SUBJECT: Project 35993.1.1 (U-4700) Caldwell, Catawba, and Burke Counties
F. A. Project NHF-321(18)
Proposed US 321 Widening from US 70 in Hickory to Southwest Boulevard in Lenoir

**Post-Public Meeting
Meeting Summary**

Figure 11: (Recommended) Revised flyover design, October 2017 public meeting with additional bridge over stream and increased slopes

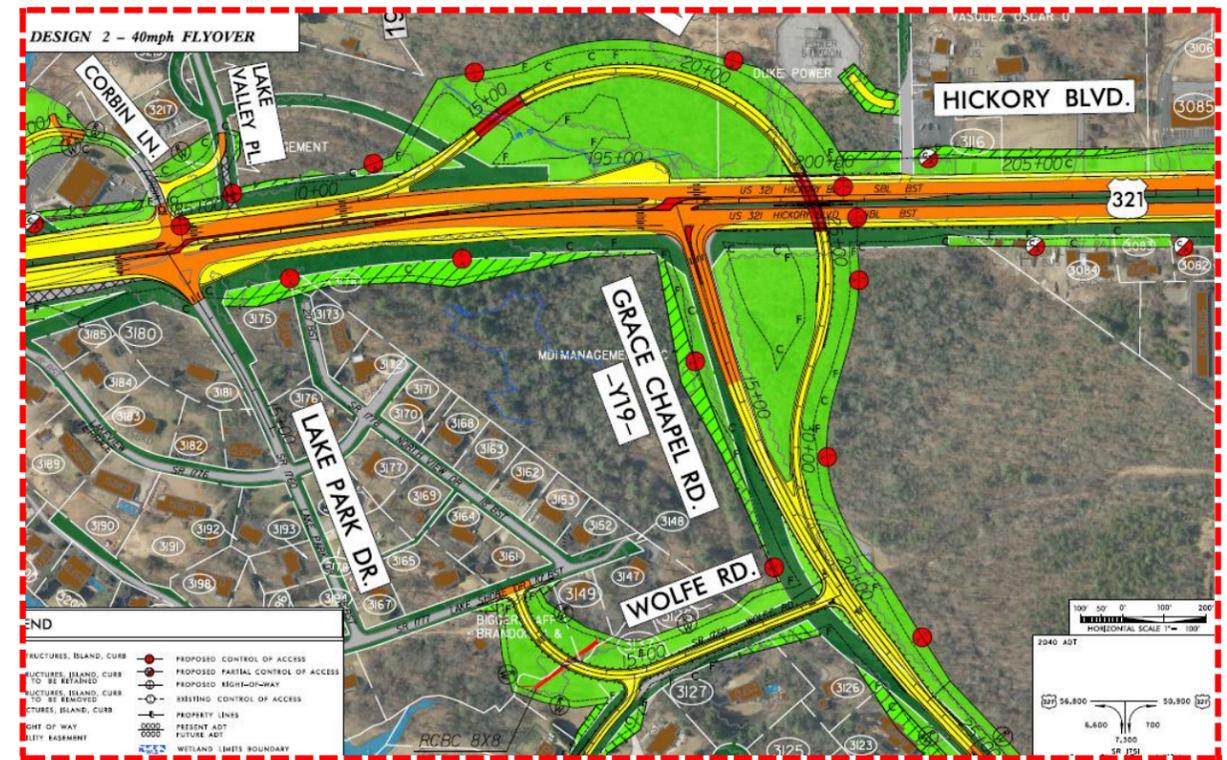
2. **Comment:** Why is it necessary to use land on Grace Chapel Road if the existing road is moved further to the right? Concerned about property impacts along this section of Grace Chapel Road. (x2?)

4. **Comment:** How long will the merge lane be on U.S. 321 South coming from Grace Chapel Road? Will it be long enough to be safe?

Response: Some right of way or temporary easements on Grace Chapel Road will be needed to tie the new flyover into the existing road. During the final design process, the project team will minimize impacts where feasible to property along Grace Chapel Road.

Response: The merge lane at the end of the flyover from Grace Chapel Road is approximately 850 feet long, and has been designed to meet the criteria for merging at the design speed on U.S. 321.
